From: ANDRE SMYK [REDACTED]
Sent: 21 June 2016 13:45
To: DevelopmentControl & DevelopmentManagement
Cc: BSCP; Green , Donna Councillor; cllrkevinwilliam@barnsley.gov.uk
Subject: Planning Application 2016/0623 re 132 Park Grove Barnsley S70 1QG (FAO Rachel RODDIS-Case Officer)

I am writing to formally object to the planning application above-proposed cellar conversion to form 2 bedroom self contained flat. My comments are as follows:

LAYOUT AS PROPOSED

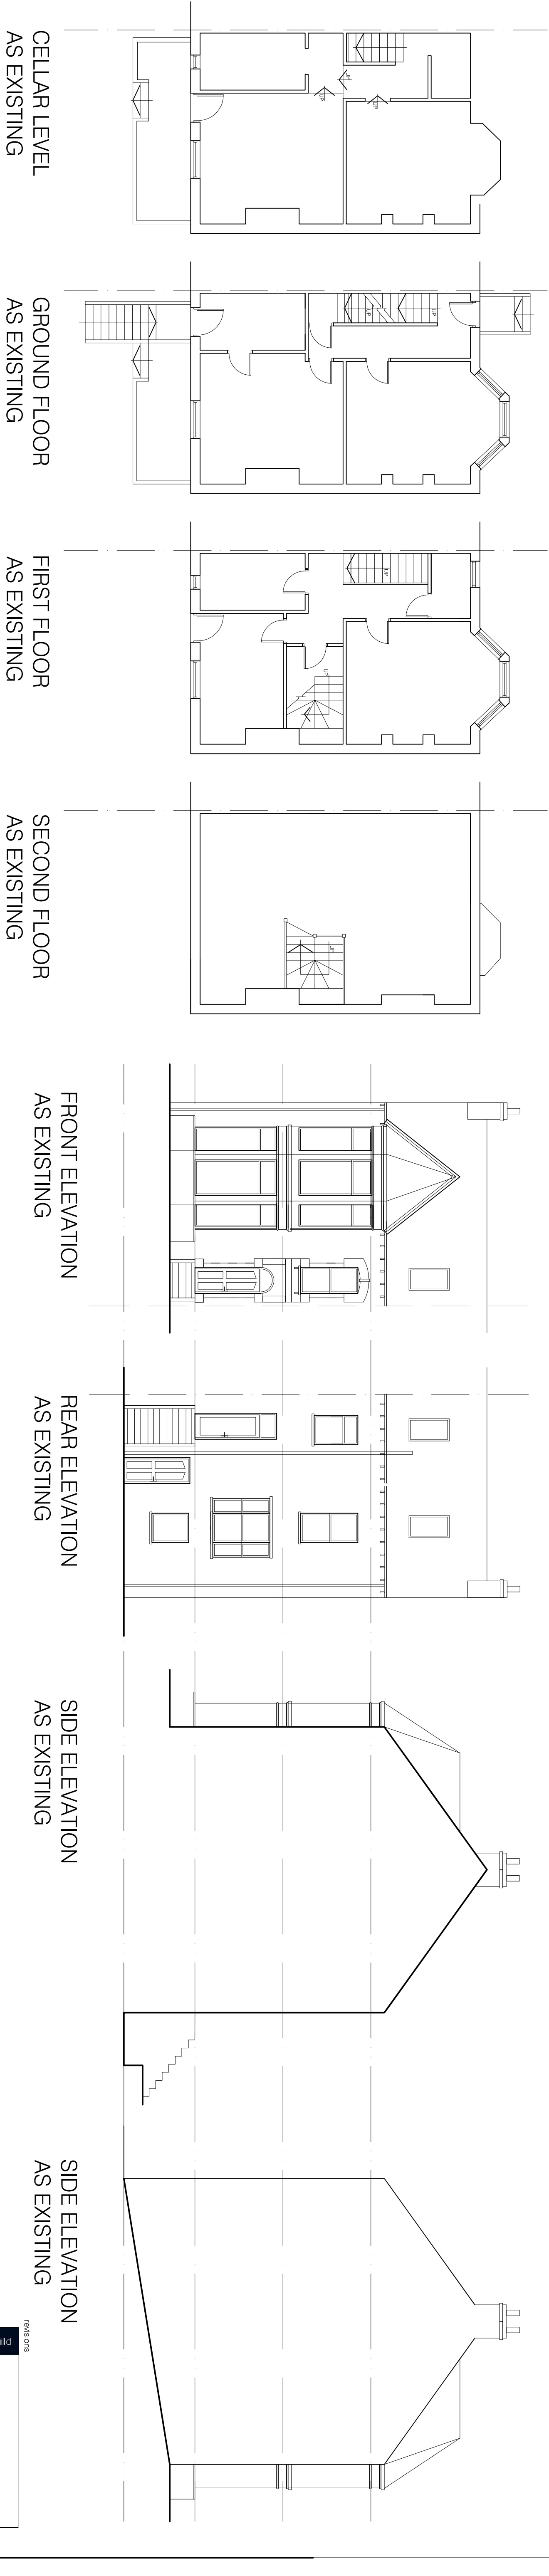
1. The application is effectively for change of use of the existing dwelling. The change of use arises by virtue of the proposed subdivision via creation of a basement flat. The physical works for which planning permission is also required are construction of a stair and light well to the front of the property.

13. It has been stated by the developers' agent that designs of this type (creation of stair and light well beneath centre bay window to create basement flat) are commonplace in this area. I disagree with this statement. I have only seen one such property which is on Park Road. I think the conversion of these family homes in this manner alters the overall appearance of the building to the detriment of the visual amenities of the area.
